4 September 2025

**RE: SD-77820496 – Submission
Sydney Olympic Park Metro Station Over and Adjacent Station Development – Concept
Amendment**

DRAWING TITLE
SHADOW DIAGRAMS-OPTION E - PROPOSED
CONTEXT

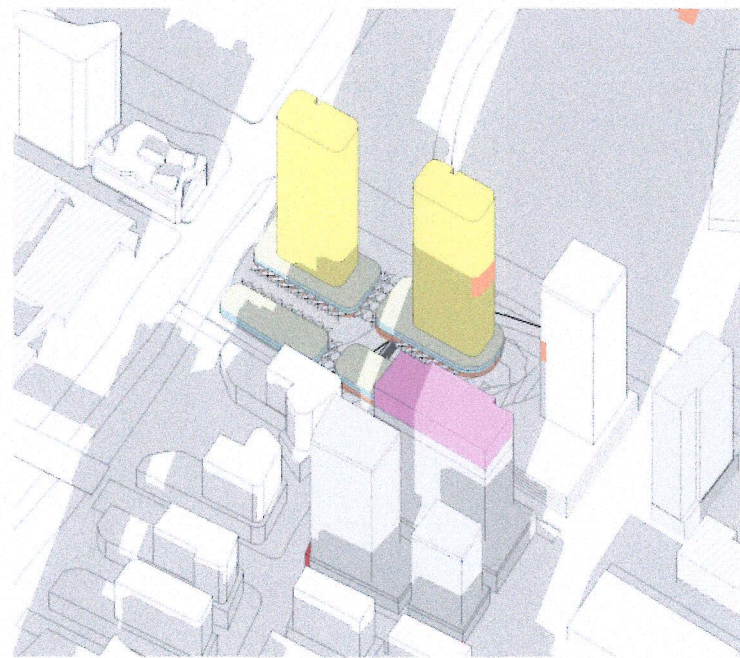
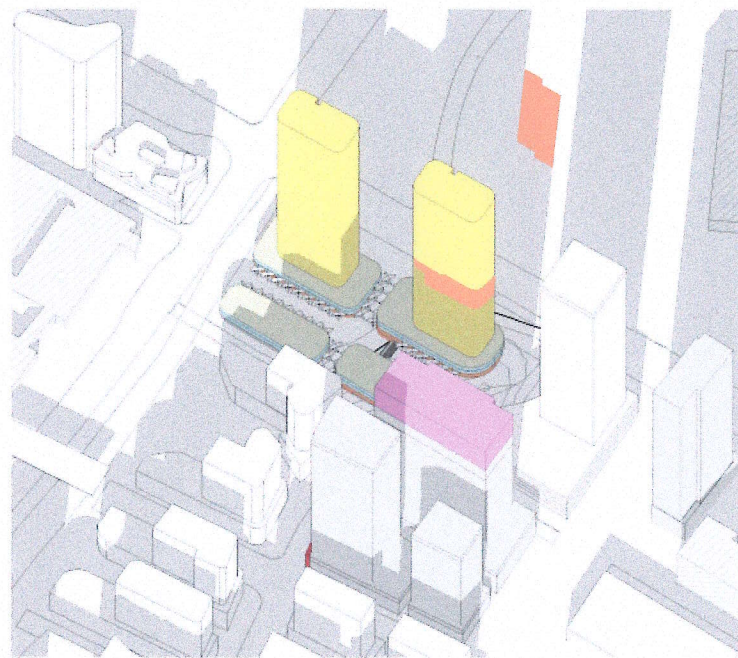
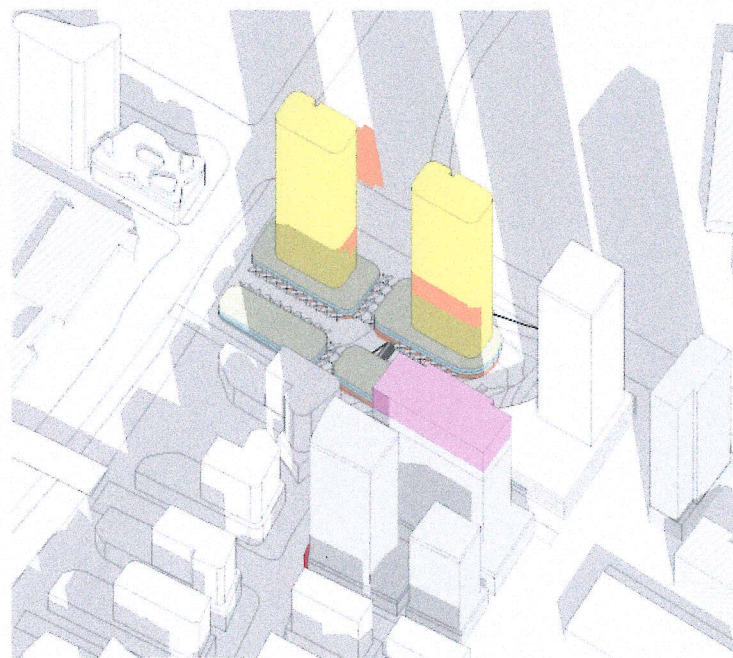
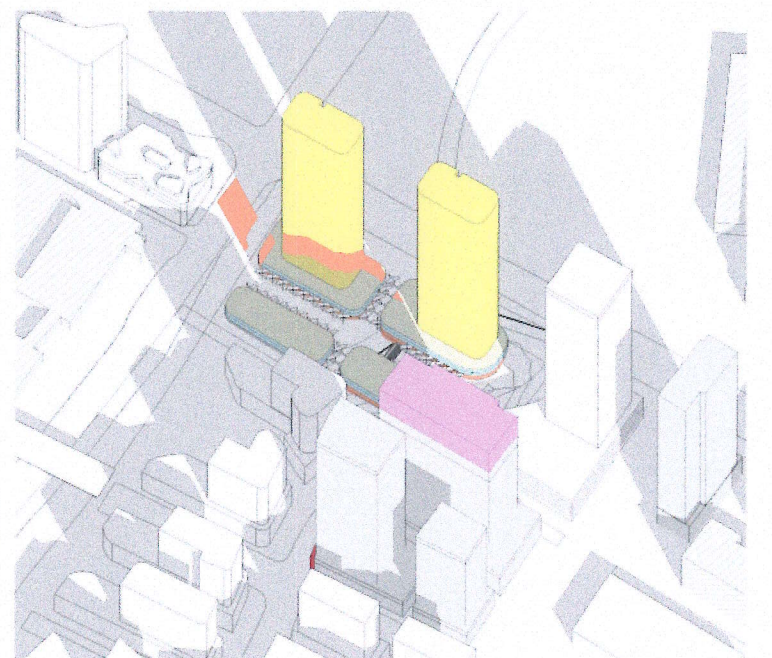
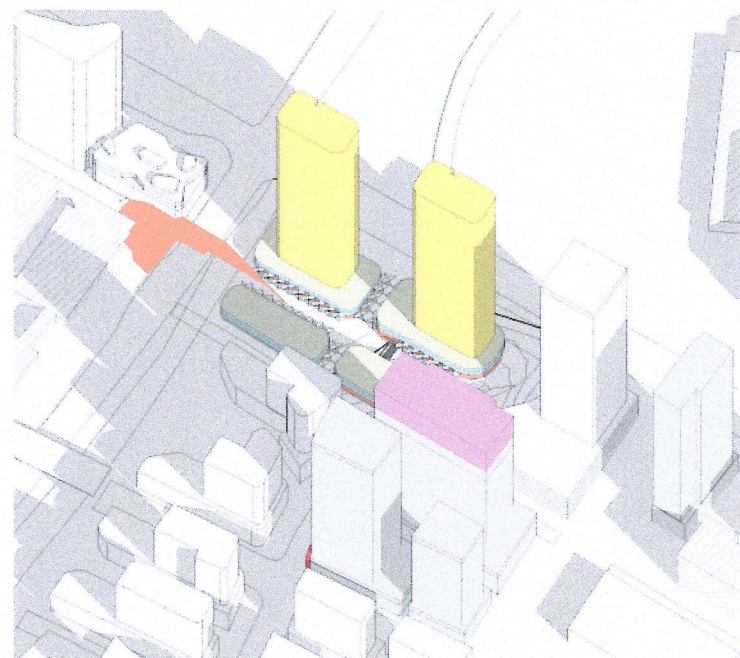
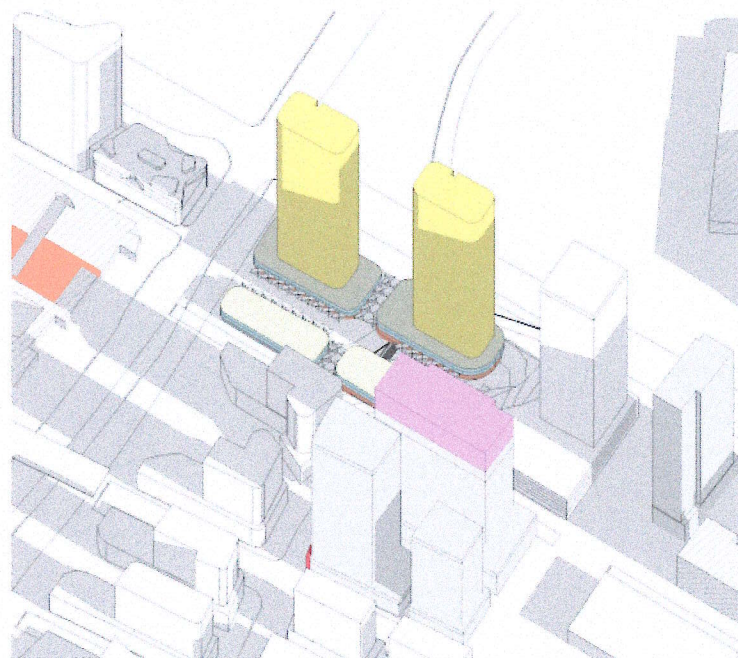
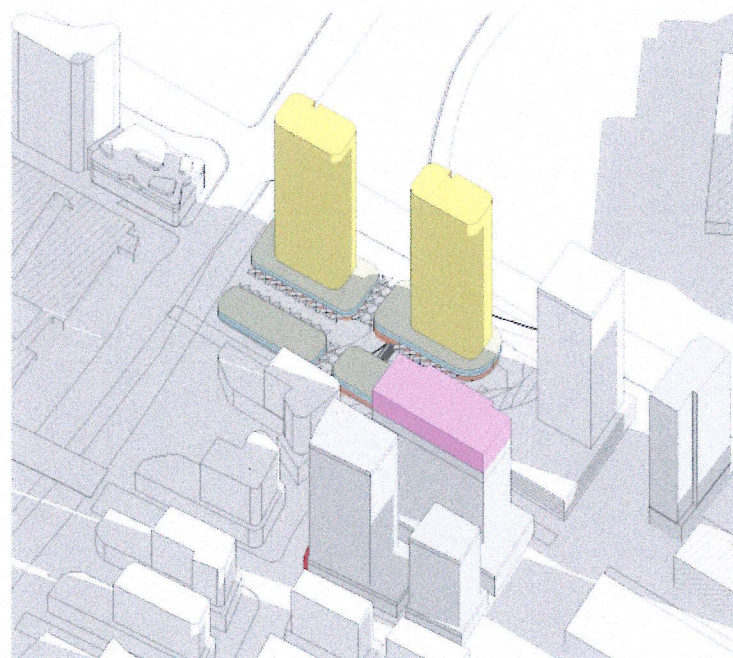
- Additional overshadowing of Site 50 on the winter solstice from 9am through to 1pm, which adds to the significant overshadowing of the site approved as part of the original Concept SSDA (SSD-35283699) when considered cumulatively with future development on Site 48, with these impacts detailed in Dunnet Group's submission to this previous SSDA (**Attachment A**).

- The proposed additional height will cumulatively result in a considerable increase in overshadowing as illustrated in the Shadow Diagrams prepared by Curzon + Partners in relation to the reference design for the site (**Attachment B**). The additional shadow caused by the proposed Amending Concept SSDA is highlighted in orange in **Figure 2**.

- The apartments on the eastern and northern elevation of a future development on Site 50 are reliant on the morning sunlight to achieve at least 2 hours of solar access on the winter solstice. This is further eroded as a consequence of this proposal.

Recommendation 1: On the basis of the above points, Dunnet Group recommends that further work is undertaken in relation to the proposed Amending Concept SSDA including a reduction in building height and refinements to the envelope to remove any additional overshadowing impacts on Site 50 and allow for reduced overshadowing when compared to the approved Concept SSDA (SSD-35283699).
